PCU078590

State Significant Development Application Number SSD-10300.
Coffs Harbour Cultural and Civic Space.

GORDON ST ELEVATION

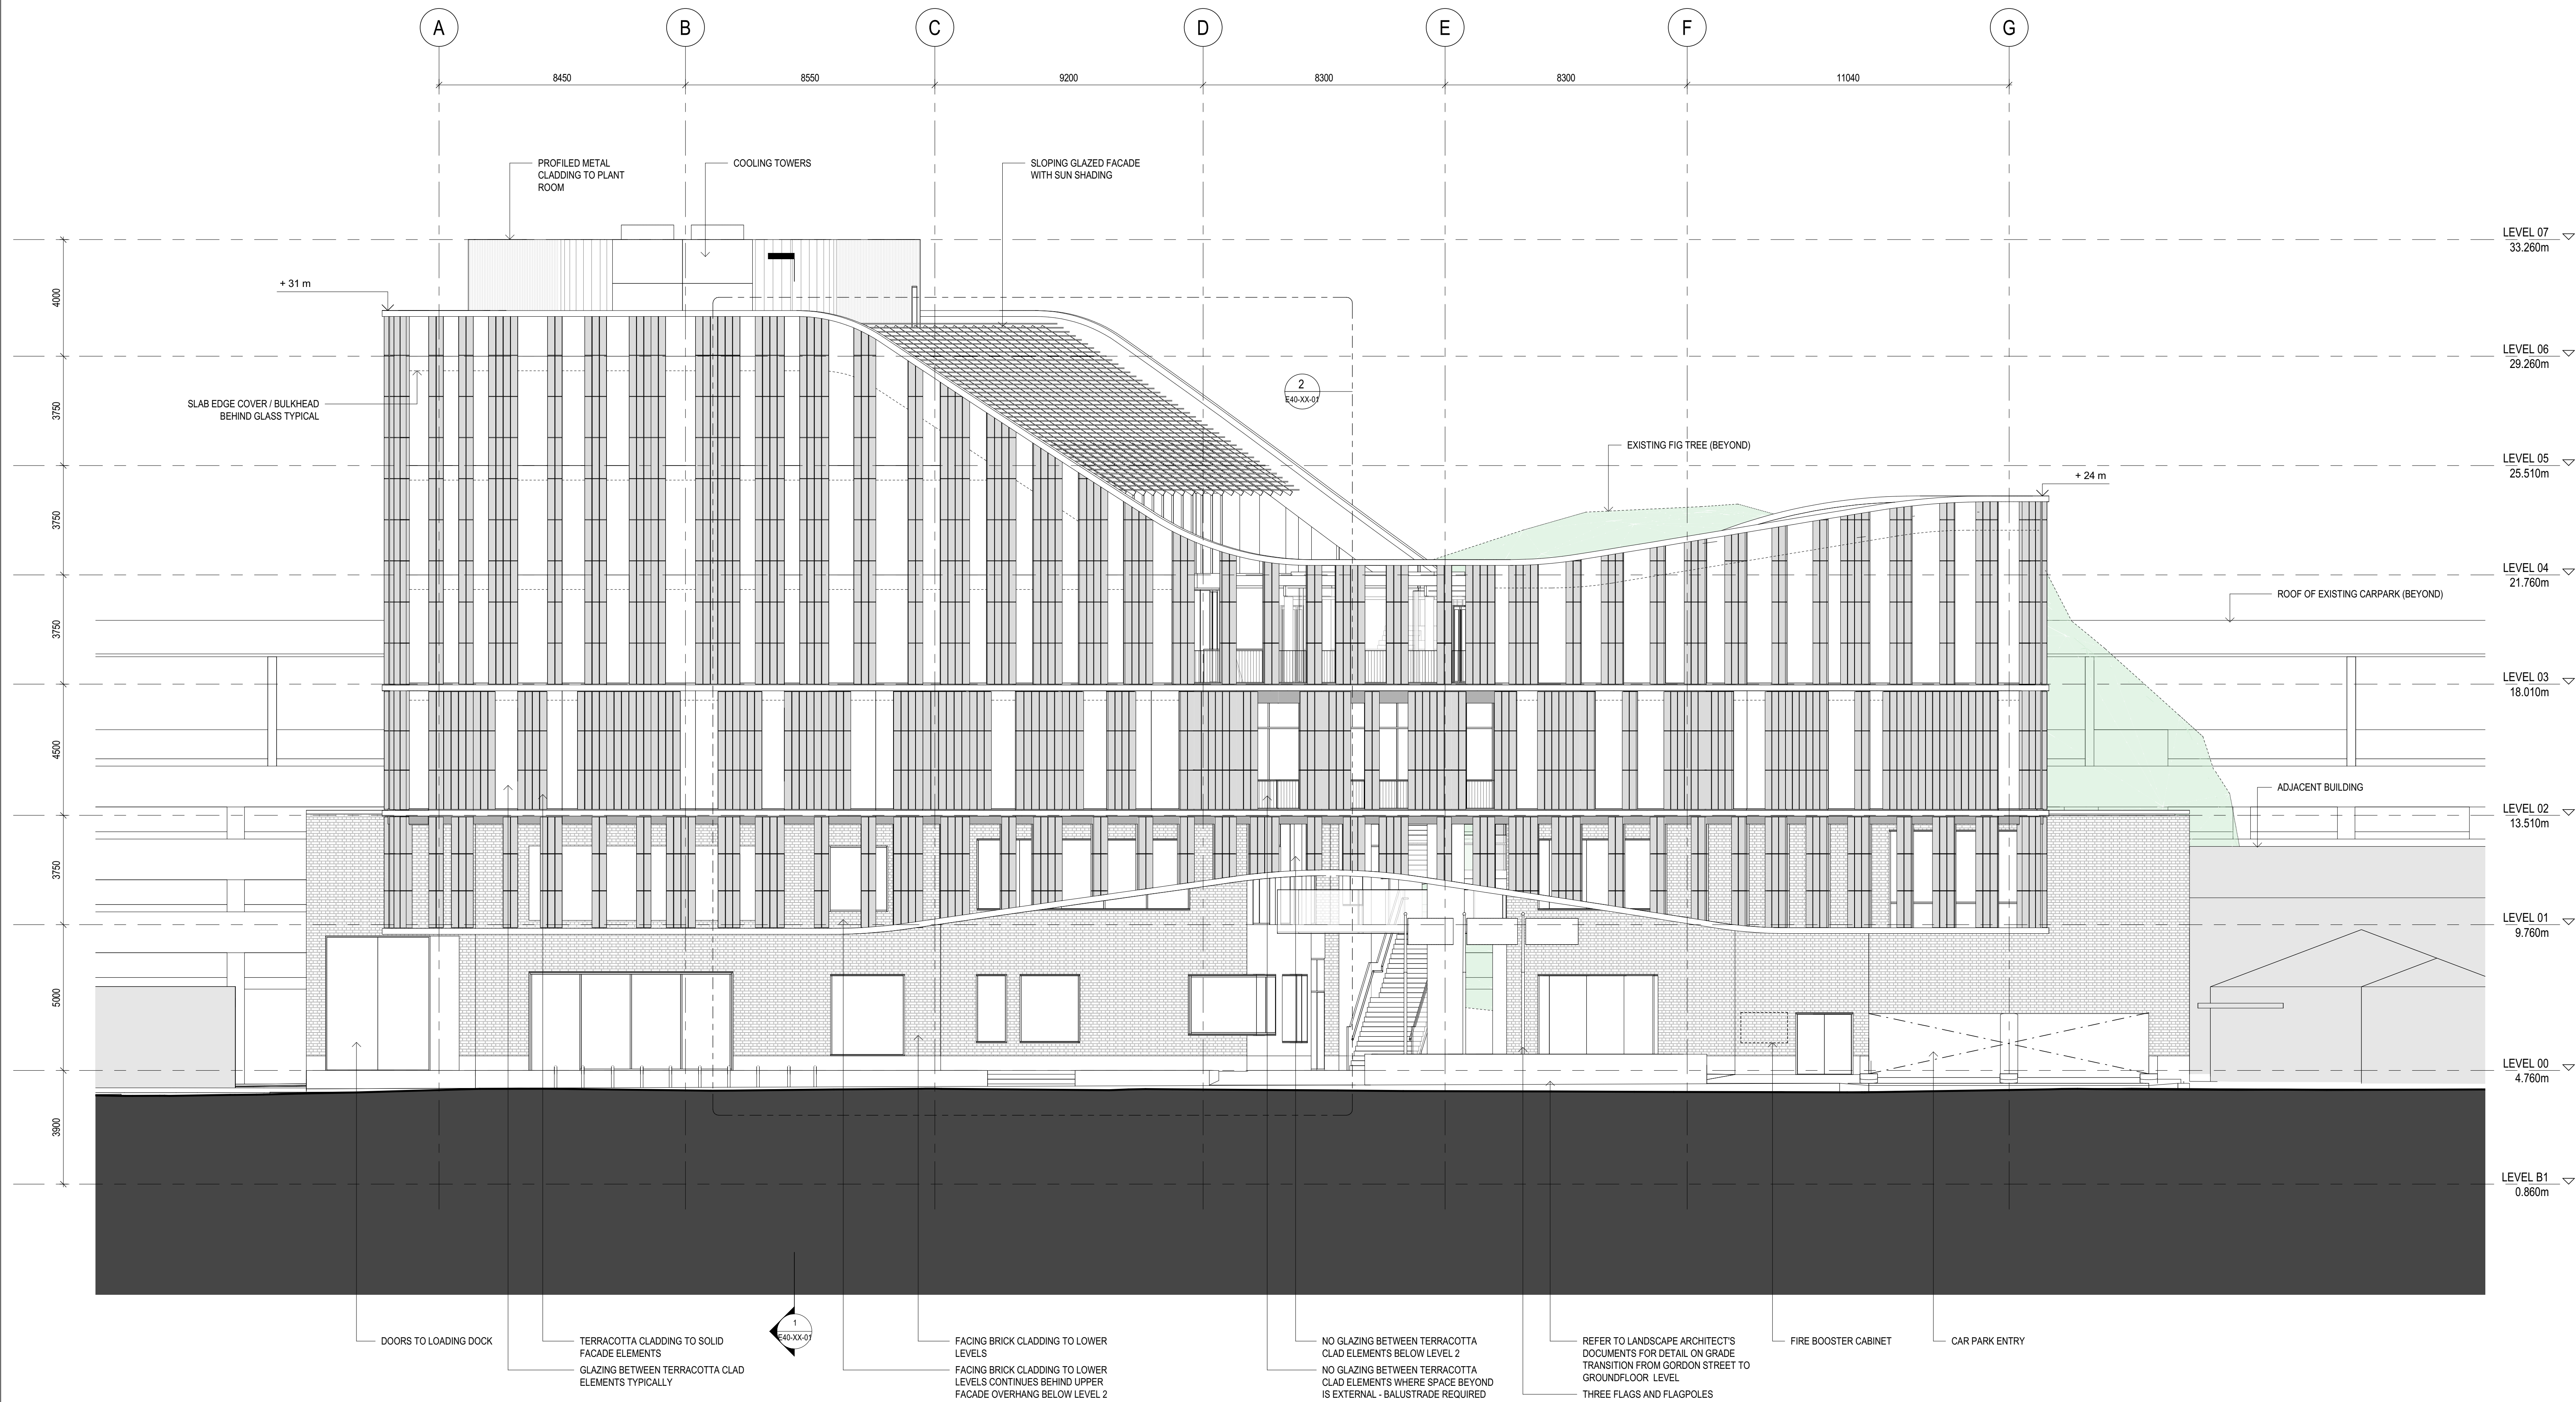
11. It is disruptive to the streetscape rhythm in that it is out of character with the nearby development, provides an unsafe arcade and fails to meet the objective of the B3 Commercial Core Zone to *'ensure that the design of new commercial buildings makes a positive contribution to the streetscape through opportunities for improved pedestrian links, retention and creation of view corridors and the provision of a safe public domain'*.

12. It conflicts with the streetscape in Gordon Street in that the proposed building is outside the context of this street having regard to the scale, existing street setbacks, design and general form of the adjoining buildings.

SECTION N-S

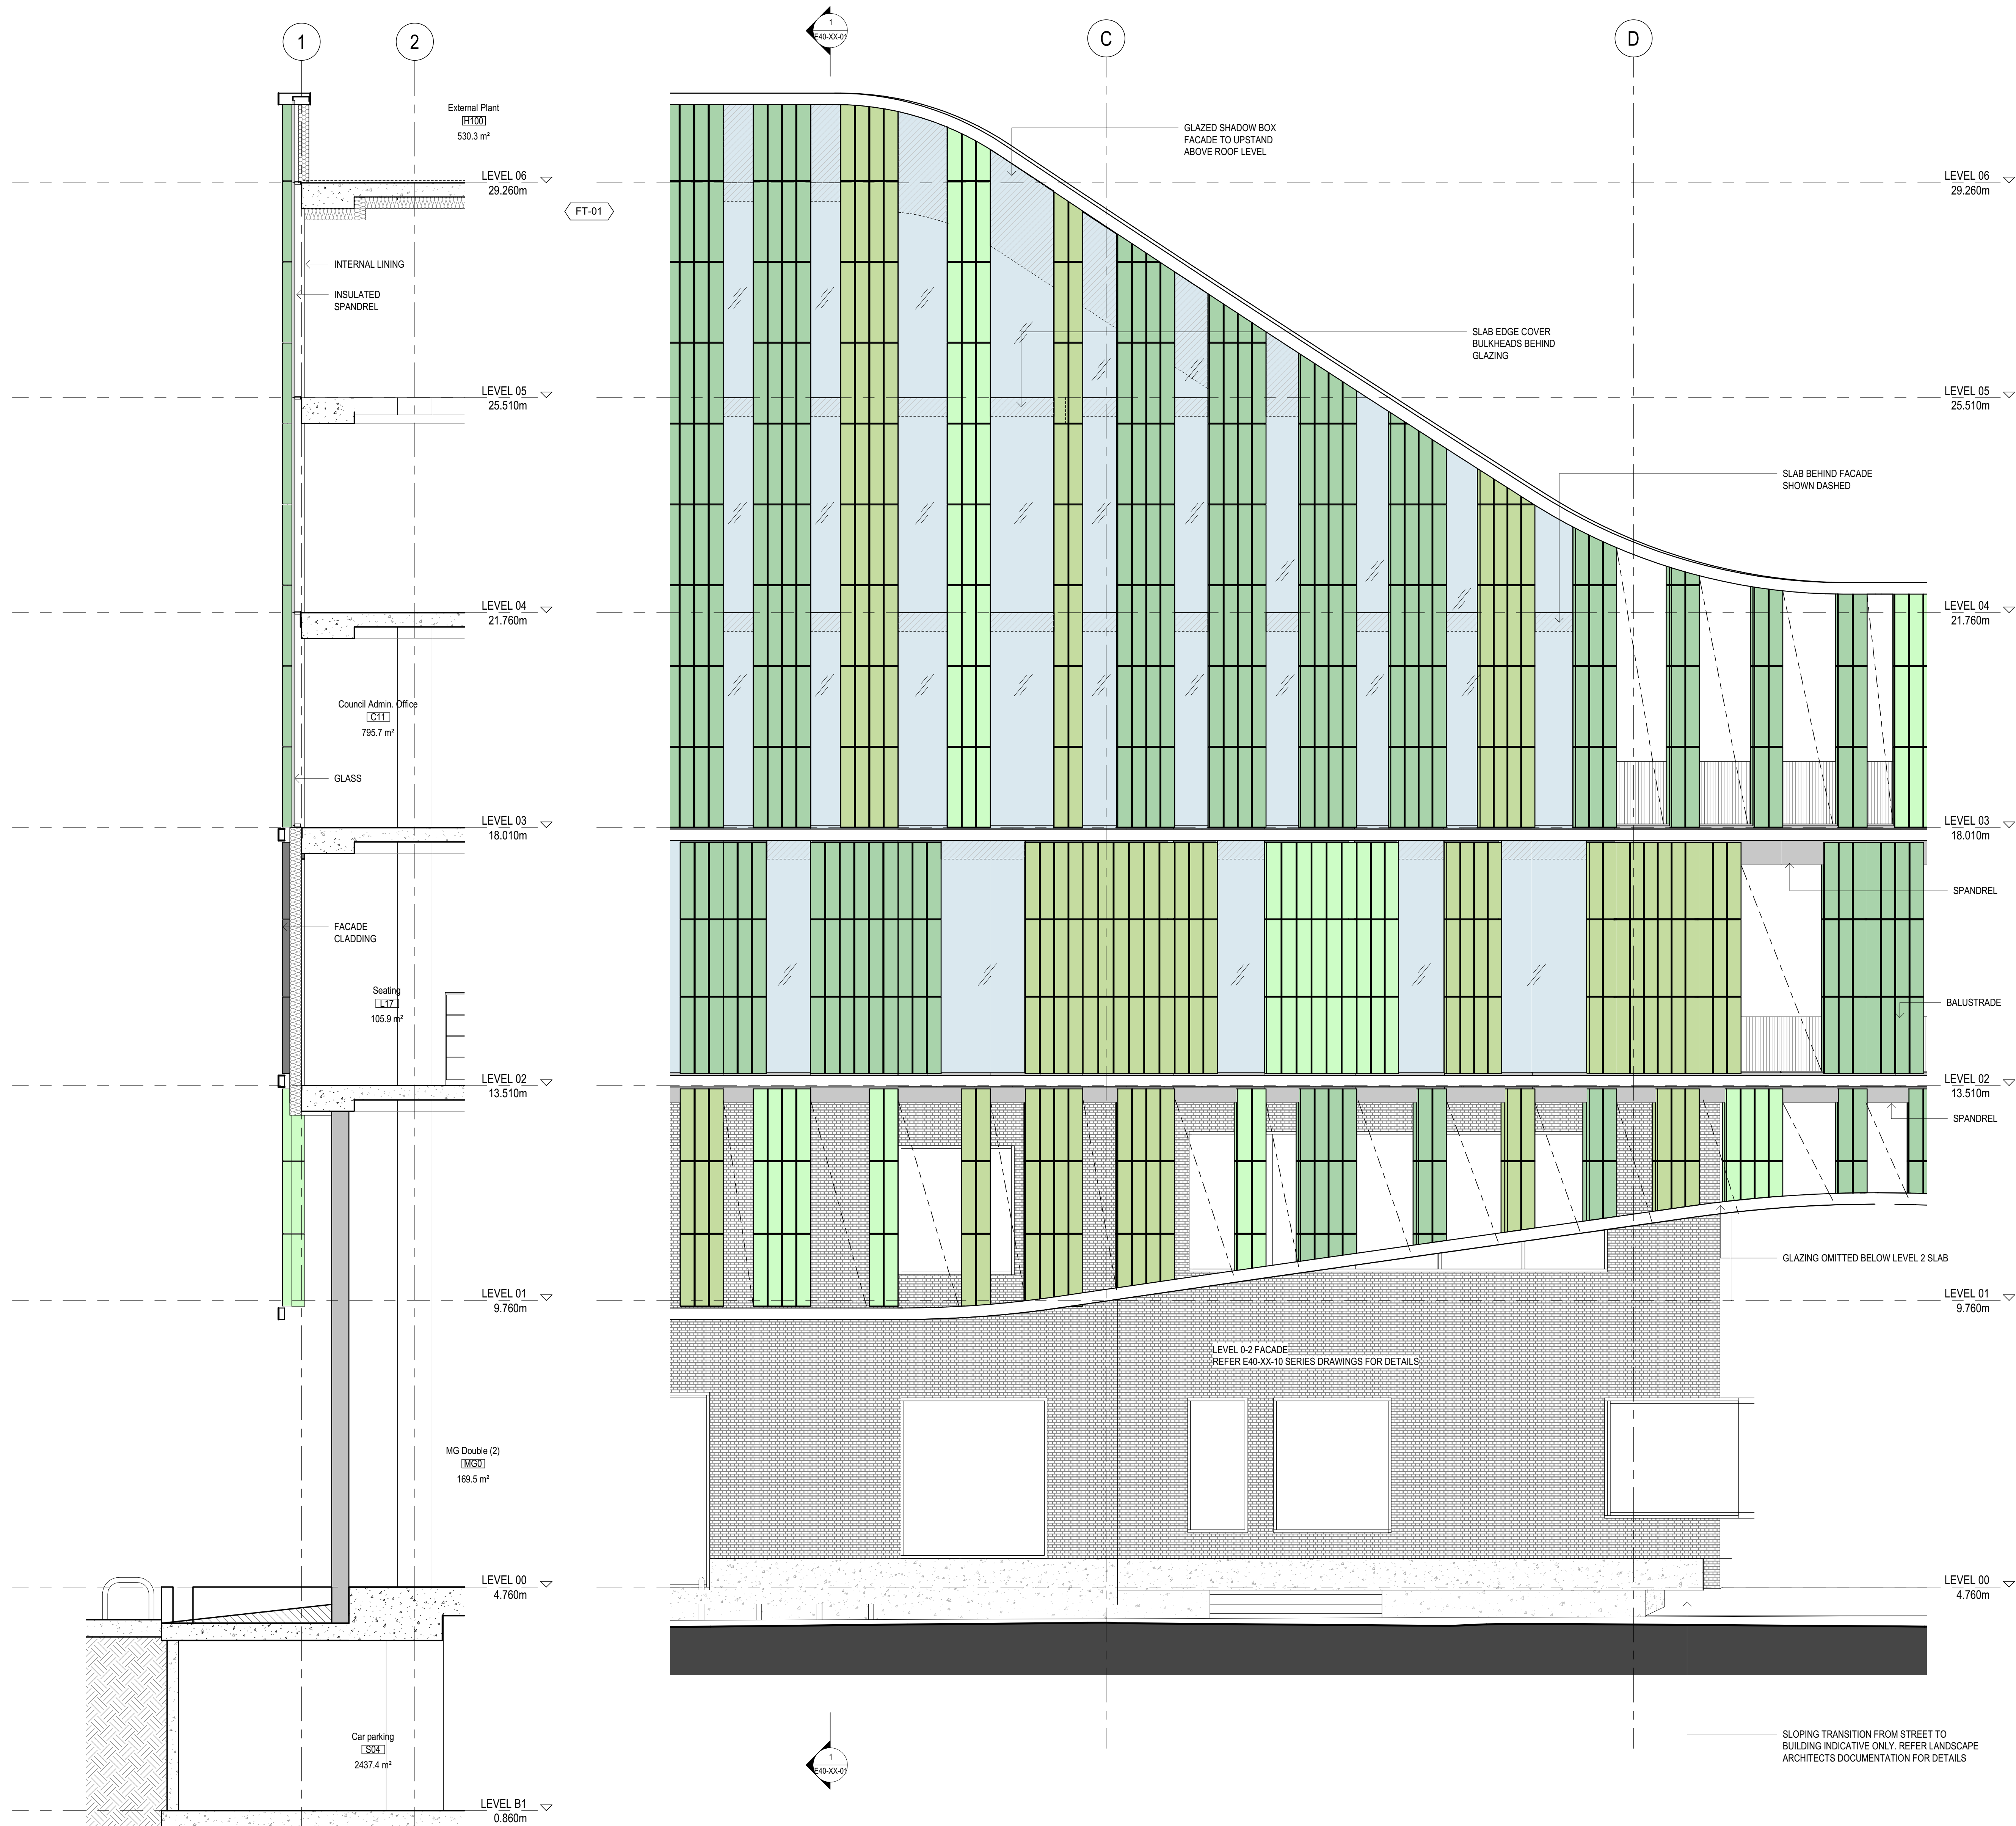
15. It exceeds the height limit of 28 m. set down by Council and an exception is not justified.
